An
Bord
Pleanála

Inspector's Report ABP-300425-17

Development	Extension to existing limestone and sand & gravel quarry.
Location	Powerstown, Nurney, Co. Carlow.
Planning Application to An Bord Pleanála	
Related Substitute Consent Files	ABP-300034-17 & ABP-300037-17
Planning Authority	Carlow County Council
Applicant(s)	Grant Thornton (Receivers)
Type of Application	Further quarrying under section 37L
Observer(s)	Philip Morrissey
Date of Site Inspection	15 th May & 24 th August 2018
Inspector	Michael Dillon

Figure 2: Main streams in proximity to the Site

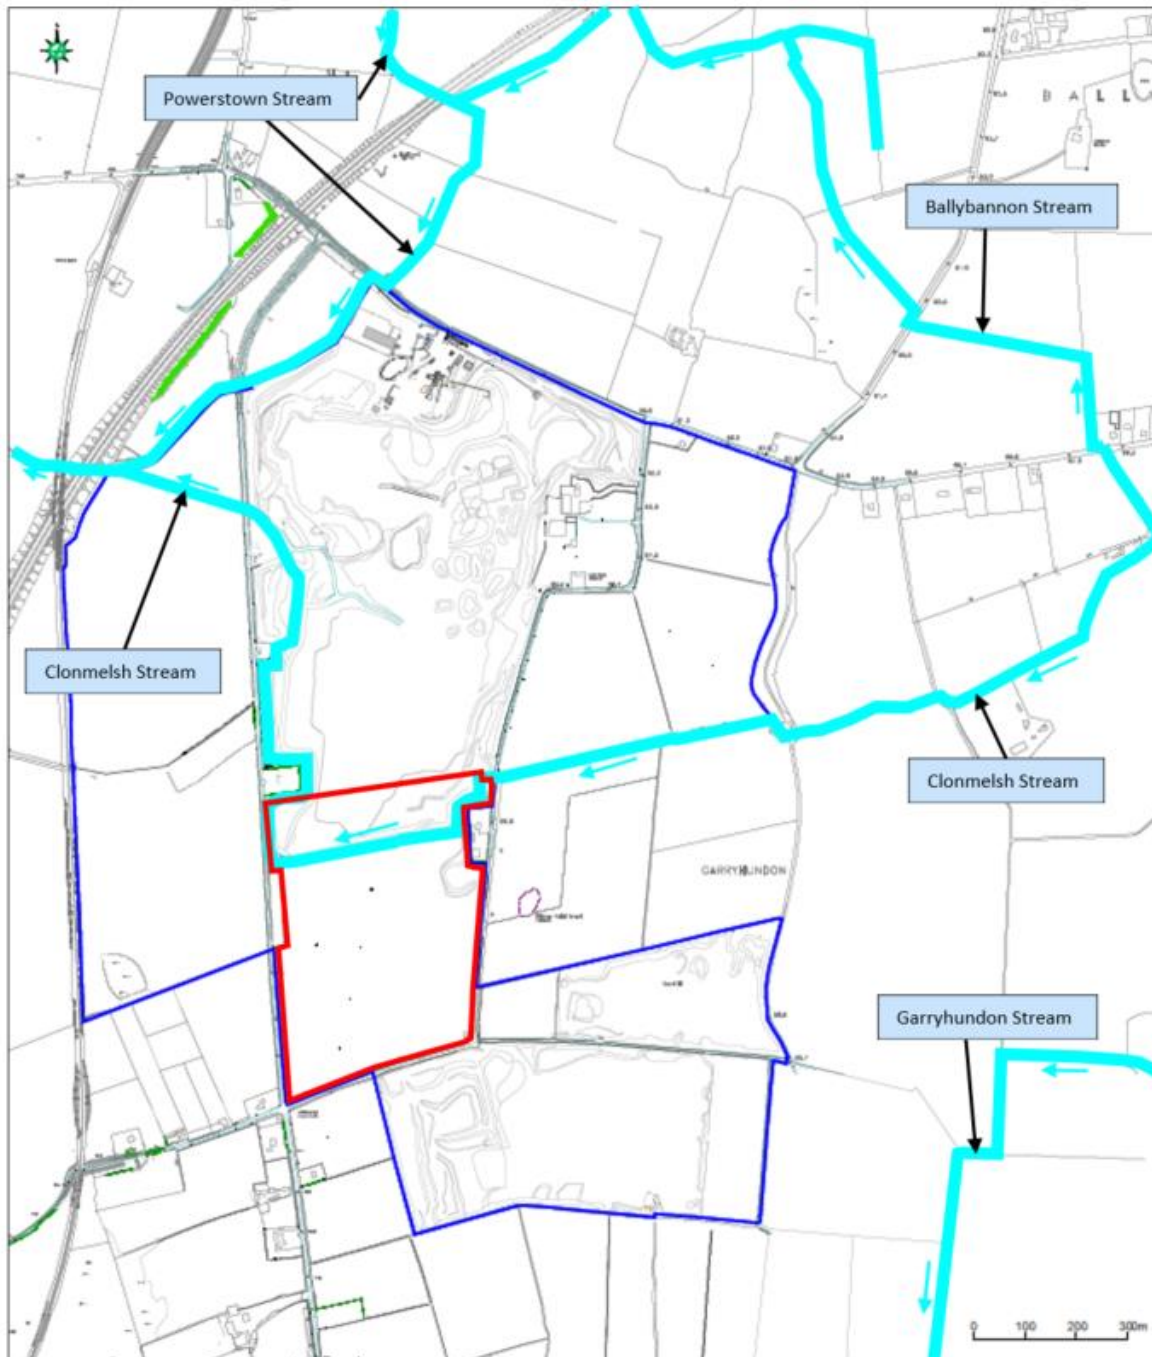
- The impact on groundwater has not been sufficiently detailed.
- The Clonmelsh Stream has been diverted a number of times over the lifetime of the quarry. Inland Fisheries Ireland should be consulted in relation to the

re-routing. The Clonmelsh Stream discharges to the Powerstown Stream – and does not form part of the controlled discharge from the quarry. The EIAR refers to rerouting in an anti-clockwise direction, whilst the NIS refers to rerouting in a clockwise direction. The impacts of this work on European sites is not addressed.
